About the application

Application number: 2023/93151	
What is the application for?:	Erection of additional storey to existing dwelling
Address of the site or building:	22, Crowlees Road, Mirfield, WF14 9PJ
Postcode:	WF14 9PJ

TITLE
PROPOSED GA PLANS

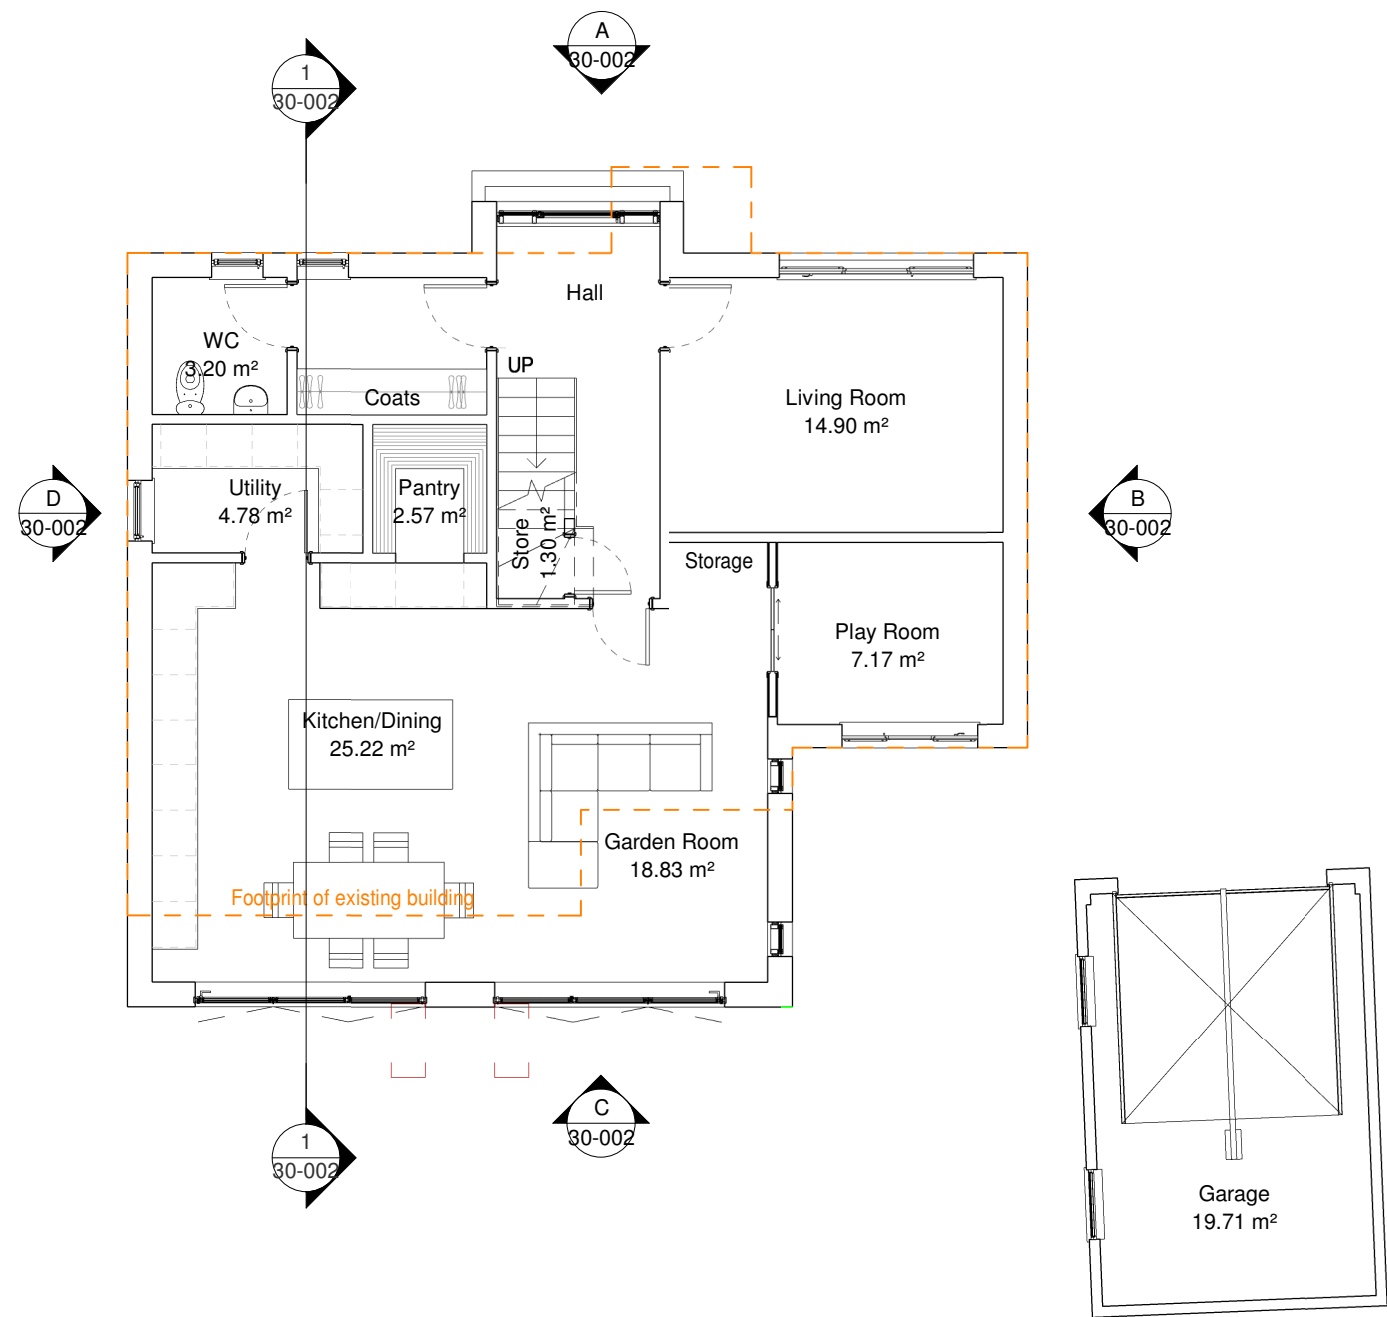
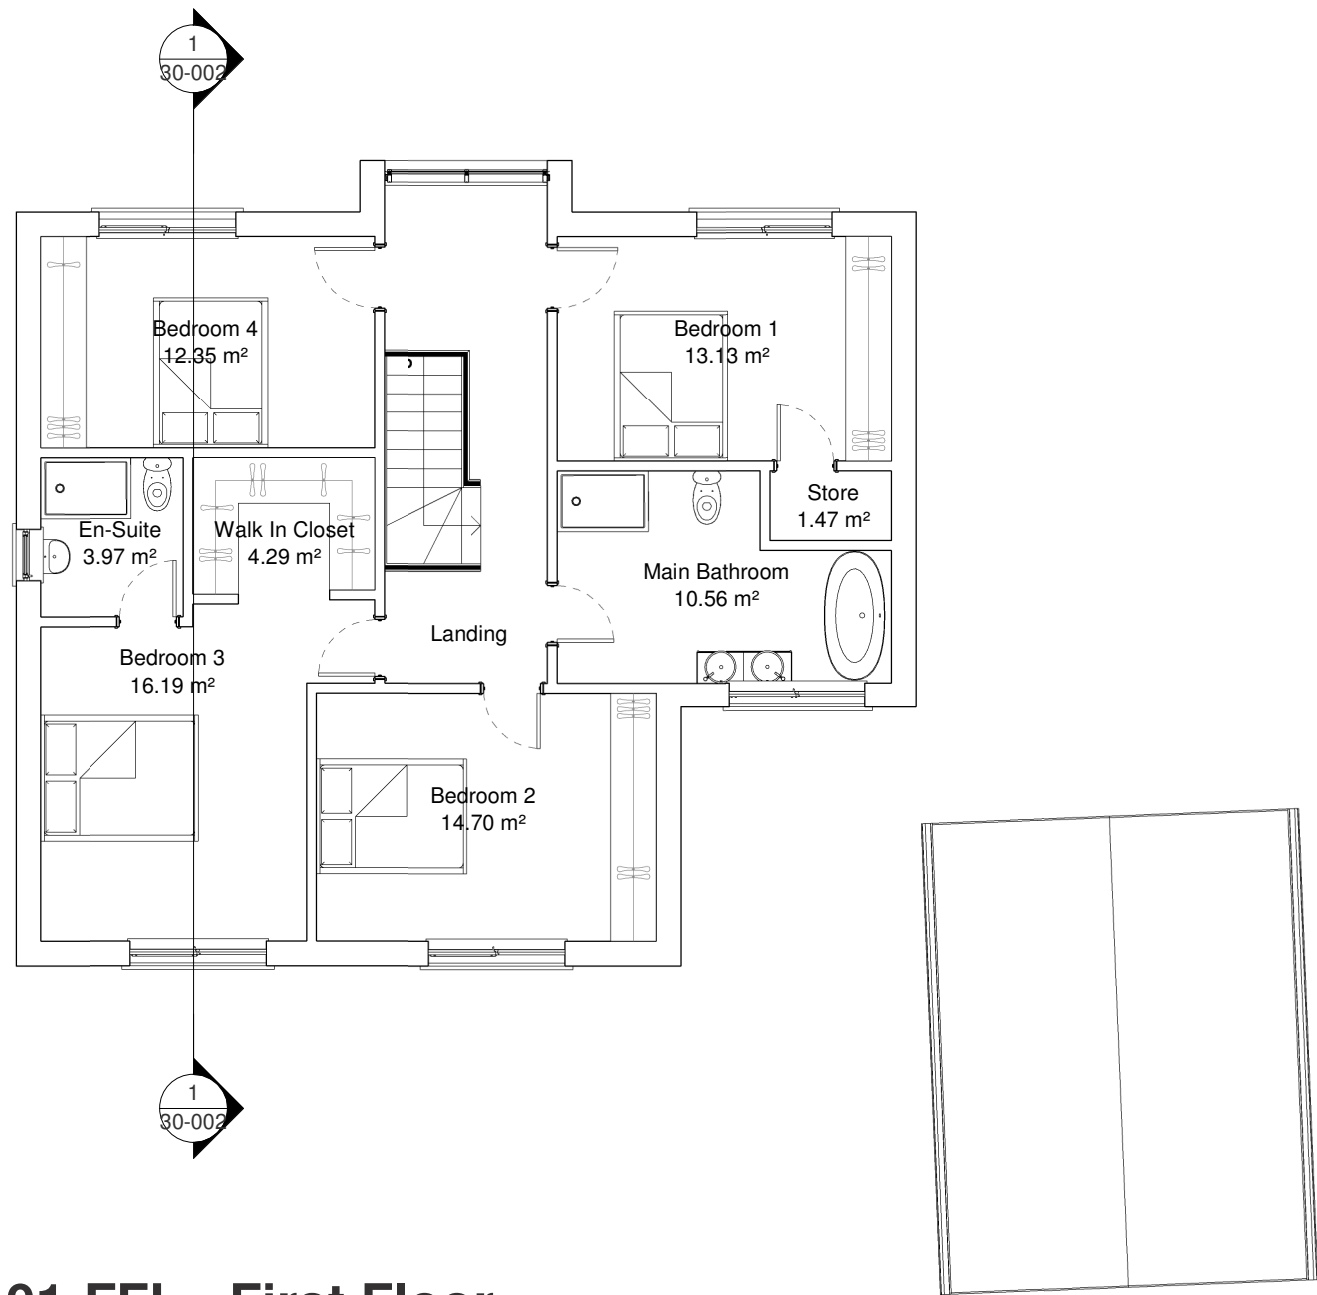
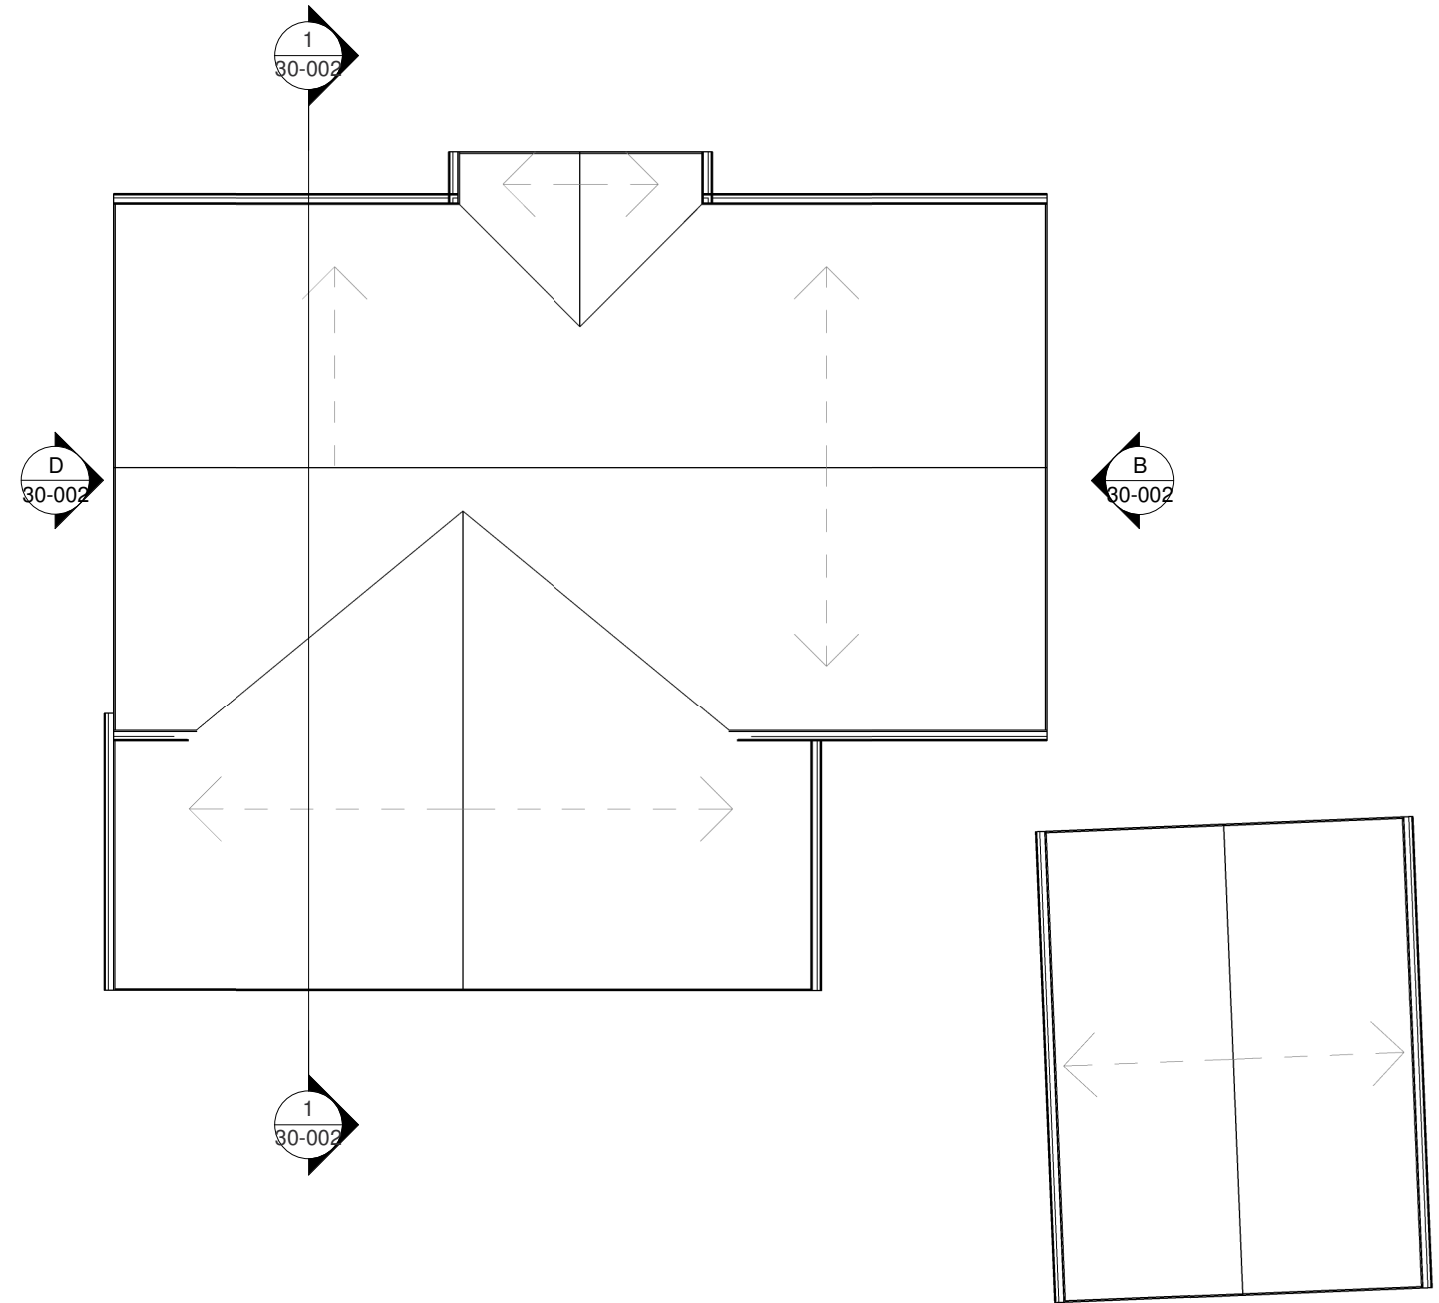
Type of comment: An objection	
Do you wish your comments to be published on the website anonymously?	Yes
We are objecting to this application. This new application adds further to the overshadowing and overbearing factors to ourselves. The application shows an increased height in the ridge and wallplate, and the hipped roof has been replaced with a full gable with windows. The wallplate height has been increased by 360mm all adding to our loss of light. The planning officer accepted the initial application to add another story as the roof was hipped and slopping away from ourselves as this would allow a flow of light past the eaves. Now with a full gable and extra height and the 2 story rear extension this would totally blank us out. The extent of the additional 2 story extension with windows will not only block our light and openness, but we will be very overlooked and lose our privacy. The gardens slope away from the front down to the rear, the rear being much lower than shown on the drawing. The garden level is about 1.2m lower at the rear, increasing the impact further. The concern with the proposed rear windows and patios, these areas often used for entertainment, is the proximity of the floor levels being near to the top of the boundary fence, leaving no privacy to ourselves and we will be overlooked. The proposed west elevation drawing does not properly represent the garden levels, we do not want floor levels and patio levels being so high that our privacy is lost and we're overlooked. Nor do we want more fencing or trees being erected to further block our light. Why not build the extension central to the plot thus not impacting neighbouring properties as much. One further insight would be to have a vehicle turning area. This application for 4 double bedrooms would no doubt add additional vehicles associated with the property.
